**RE: R+L Carriers Maintenance Bldg
2381 Aztec Rd NE
Grading and Drainage Plan
Engineer's Stamp Date: No Date
Hydrology File: G16D092**

Based upon the information provided in your submittal received 11/01/2023, the Grading & Drainage Plan **is not** approved for Building Permit and Grading Permit. The following comments need to be addressed for approval of the above referenced project:

**SHEET**  
**EX1**  
RLR.ALNM01

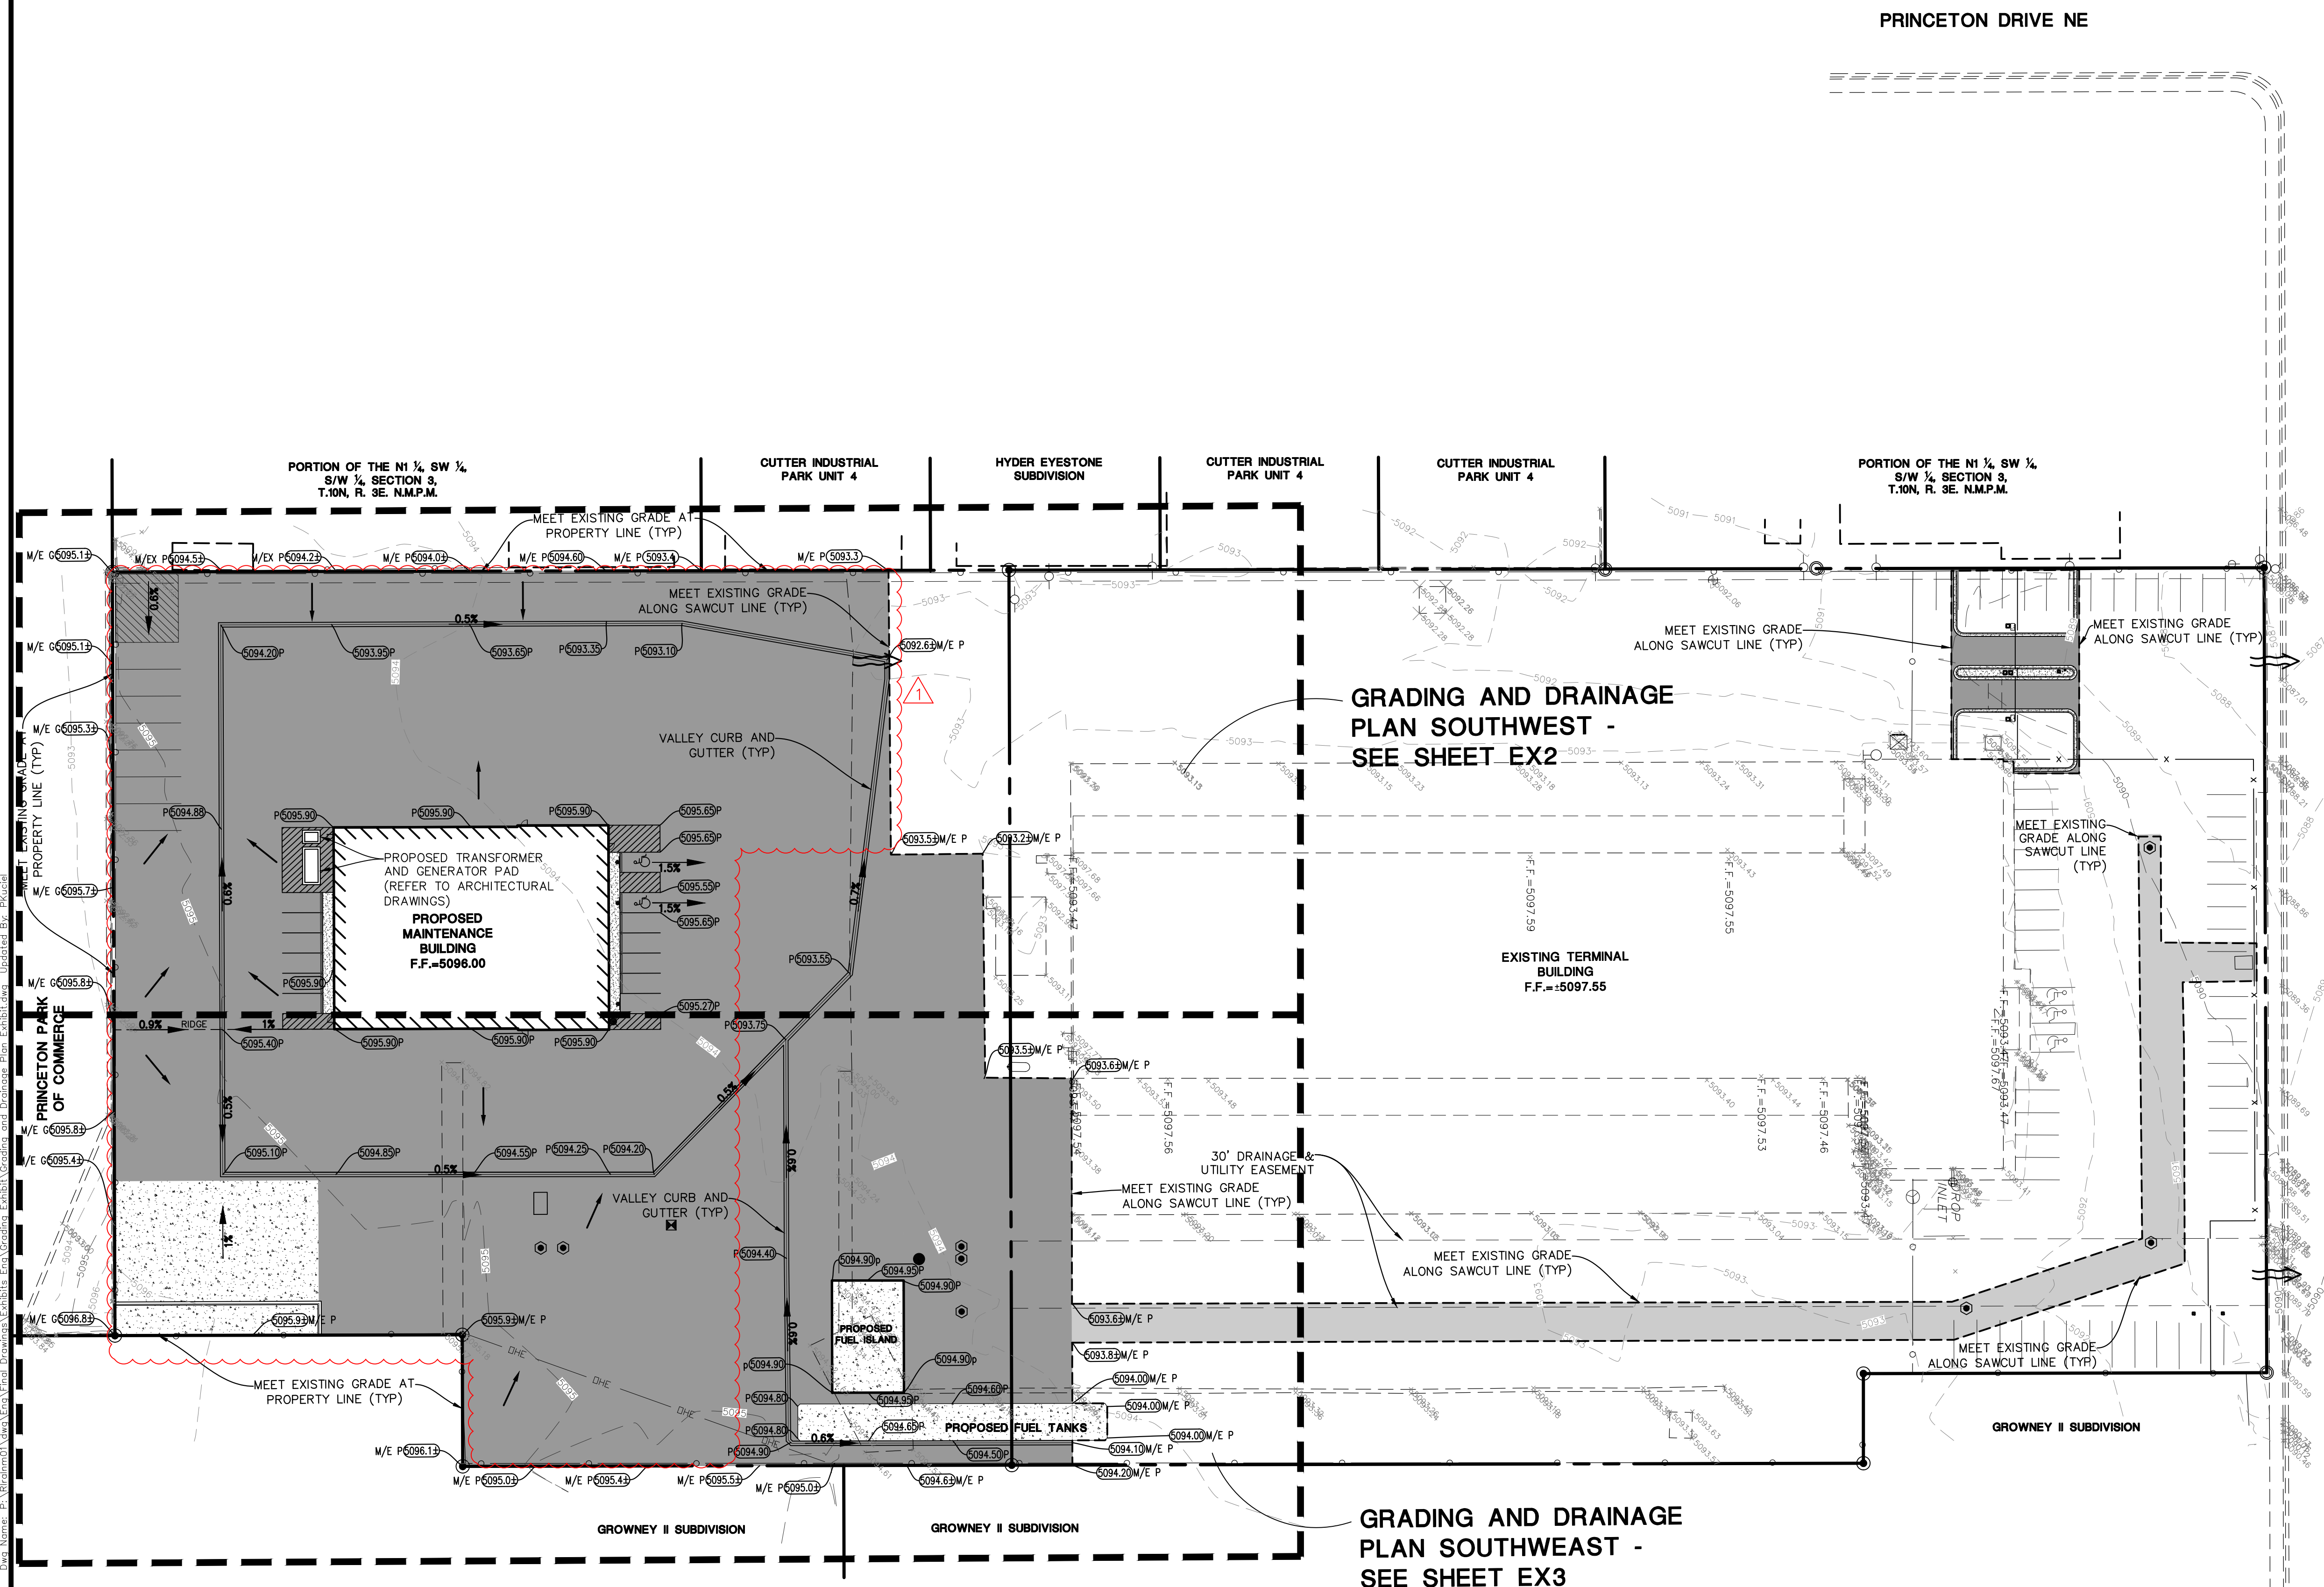
2. The runoff for this site sheet drains from the southeast corner of the property to the northwest corner. It does not appear that the provided Stormwater Quality Pond will drain to Aztec. Therefore, I would suggest removing the pond and filling out the attached Waiver of Management Onsite for the Stormwater Quality Volume (SWQV).
3. Please add a note which states, "The Owner has elected to pay the Payment in Lieu for the required Stormwater Quality Volume. The Payment in Lieu Amount = 1,114 CF x \$8/CF = \$8,912.00"

**EX4**

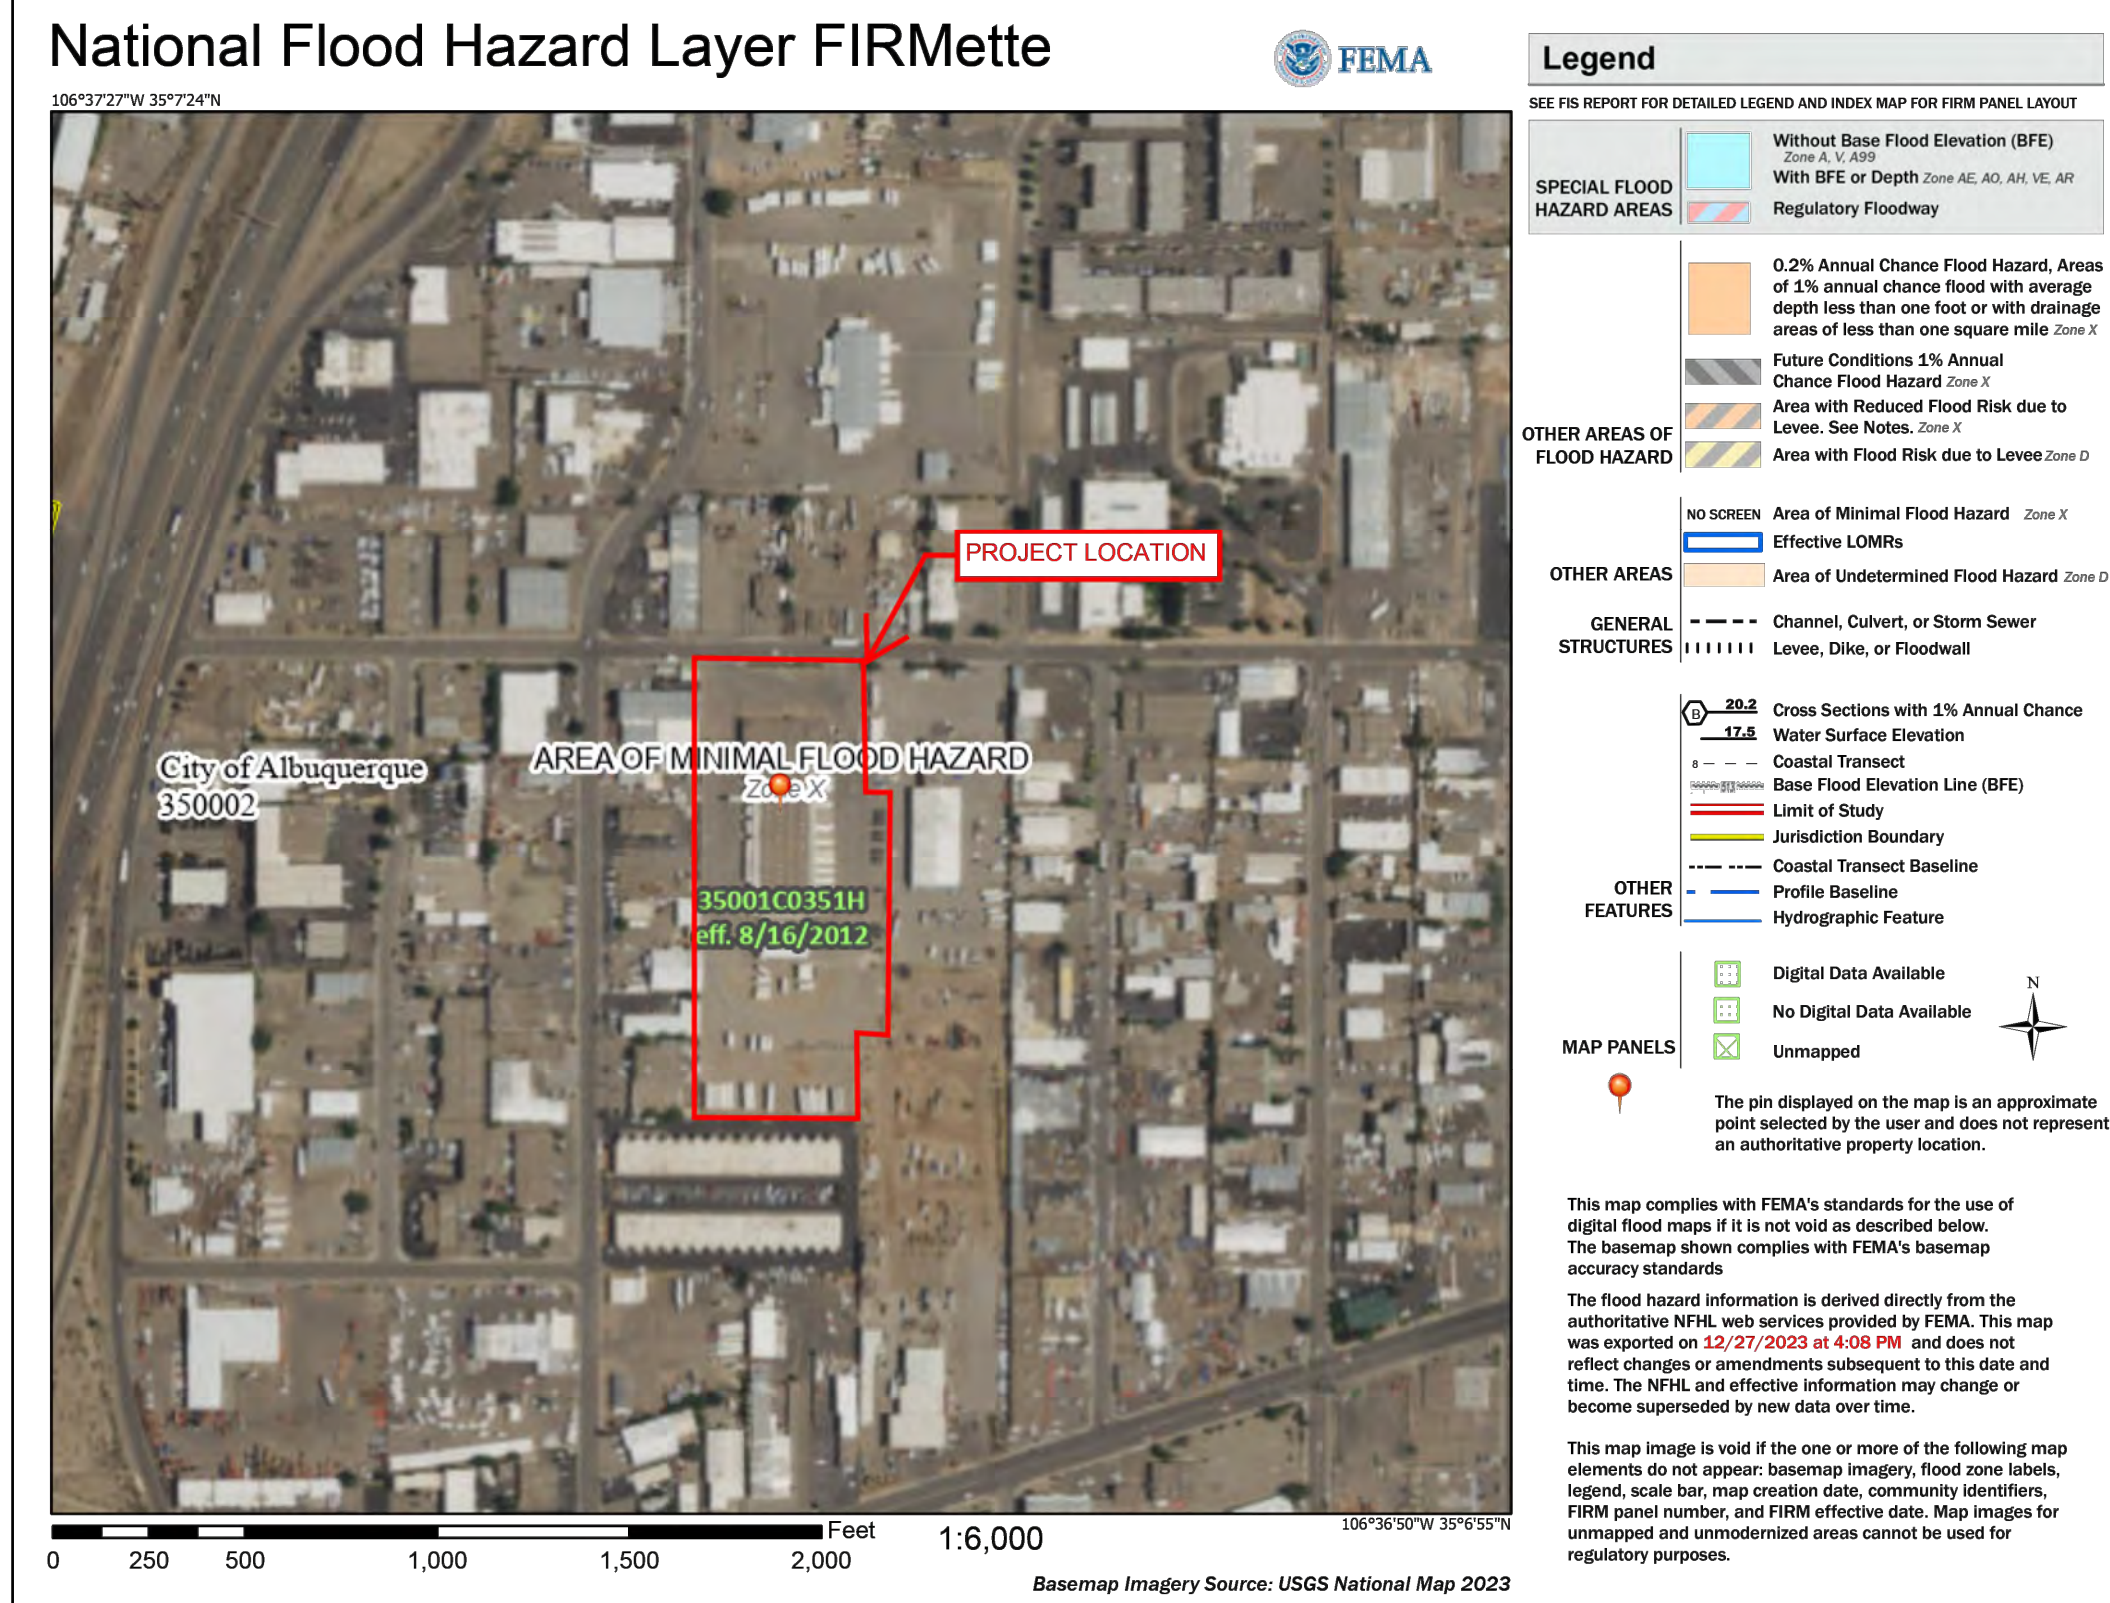
4. The narratives and drainage calculations look great. However, they are a little bit out of focus and hard to read. Since the project appears to need two sheets, please fix so that they are more readable.
